Planning Officer: Charlotte Easton
Planning Application Ref: FP/236/18/T
Location: Barnfeld, Felpham, Bognor Regis, West Sussex PO22 7DH
Description of works: Crown reduction of approx. 1-2m to 1 No. Beech Tree
Reasons Given: None given

REDUCE CROWN & DEADWOOD OF BEECH TREE T1
SUBMITTING CROWN REDUCTION IN METRES

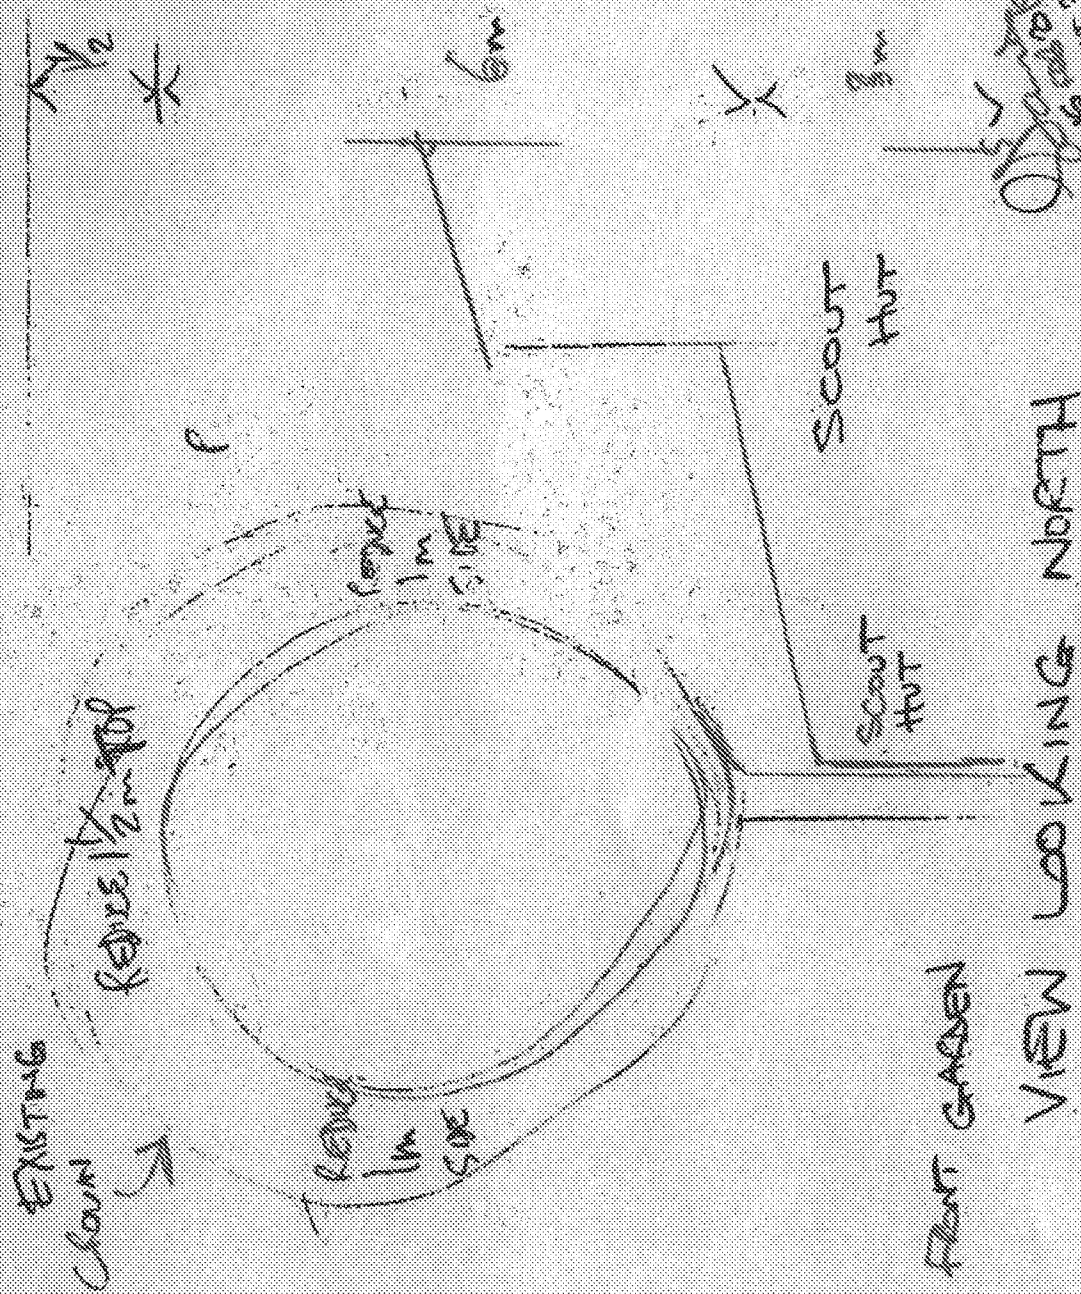
- This tree appears to be outwardly healthy and stable. It presents a dense compact crown, having been the subject of past crown reduction work.
- It grows to the front of the property and can be seen from neighbouring dwellings but has only limited visibility from publicly accessible land.
- It is very close to neighbouring built structure and discreetly located (for a tree of its size) in garden at the end of a shared footpath.
- The removal of dead branches is an exception and does not require permission.

- The proposal to reduce its overall height and spread with a view to restricting its growth is justified and consistent with previous works approved by the Local Planning Authority.
- There will be no significant loss of public amenity on completion of the proposed works.

- The removal of crown material which has developed since the last operation must be done sympathetically and with respect to established 'knuckles' so as not to extend beyond the point of origin.
- The long-term vitality of this tree is best respected when significant pruning work such as proposed, is undertaken during the late-spring to summer period (May to August). The work proposed must only be undertaken during this period.
